**Consultation Response KC Landscape**

<b>Planning Number:</b>	2025/92713		
<b>Proposal:</b>	Reserved matters application pursuant to outline permission 2023/92079 for erection of residential development of 10 dwellings, demolition of existing extension at 27 Moor Lane, widening of existing access and realignment of boundary walls and discharge of details reserved by conditions 4 (noise), 5 (BEMP), 6 (Arboricultural Impact Assessment), 7 (safety and security), 8 (landscape), 9 (LEDS)		
<b>Location:</b>	Rear of, 23 to 43, Moor Lane, Gomersal, Cleckheaton, BD19 4LF		
<b>DEVELOPER/APPLICANT/AGENT:</b>	<b>AHJ Architects</b>		
<b>Planning Officer:</b>	Louise Bearcroft		
<b>Date Responded:</b>	12.02.2026	<b>Responding Officer:</b>	Landscape
<b>Site Area (Hectares)</b>		<b>Responding Ref:</b>	<b>PP76</b>

**We have reviewed the submitted Proposed Landscape plan & Biodiversity Enhancement & Management plan**

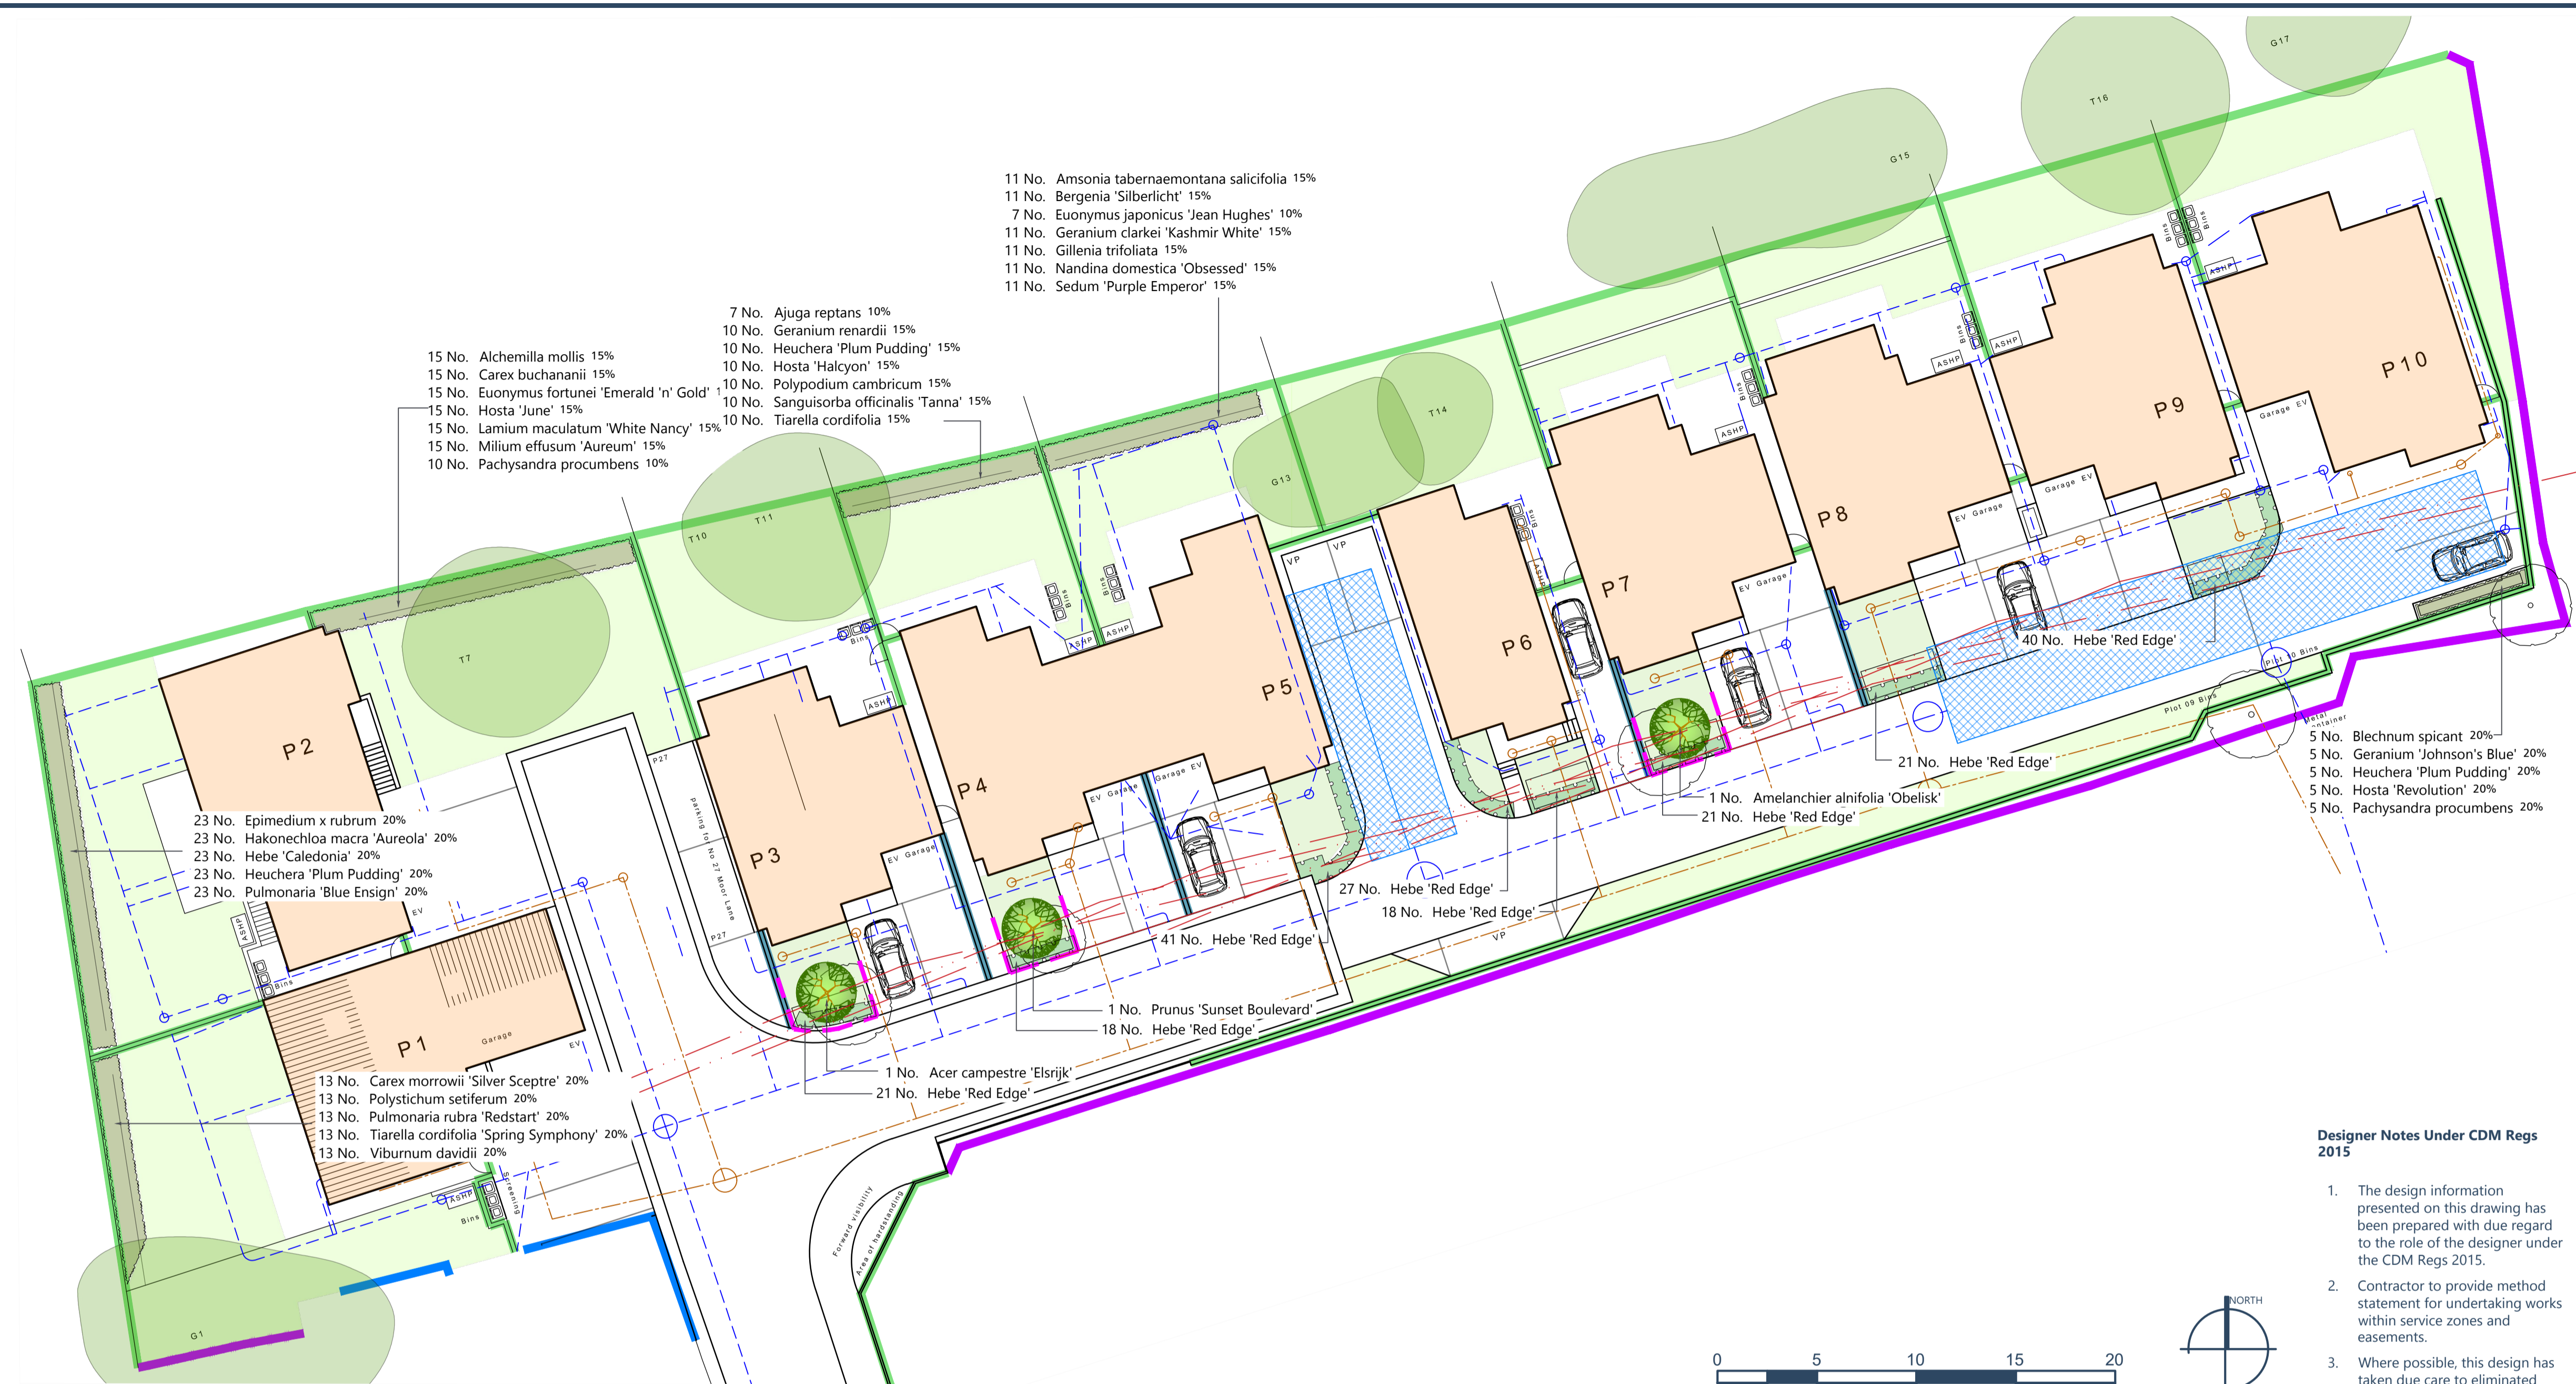
This Proposed Landscape Plan 2539-D-20-004 lacks the level of detail required for Reserved Matters approval or for the discharge of the landscape condition.

At present only an indicative shrub mix is listed and there are also too few details as to the proposed frontline hedge planting. The proposed landscape plan and full planting details will need to be included and referenced in the management plan – and long term management and maintenance operations included. At present only a scrub list is included in the Biodiversity Enhancement & Management plan which does not reflect the species in the indicative list submitted on the landscape proposals Plan. The Landscape Maintenance and Management Plan needs to include and relate to details of the proposed landscape scheme.

- Plans should clearly show the impact of the proposed landscape planting on drainage infrastructure, stats and visibility spays, particularly with proposed frontline tree planting/ trees in front gardens.

To progress the RM application, a full and detailed landscape scheme must be submitted, including (but not limited to):

- Hard landscape details: surfacing materials, boundary treatments, levels, retaining structures, kerbs/edgings, site furniture, etc.
- Soft landscape proposals:

- Full planting plans at appropriate scale
  - Plant schedules (species, quantities, sizes, planting densities)
  - Details of grassland and hedgerow establishment

- Confirmation that no potentially invasive or inappropriate species are proposed
  - Root barriers clearly shown on the landscape plan for any native hedgerows or trees within 5m of the Highway.
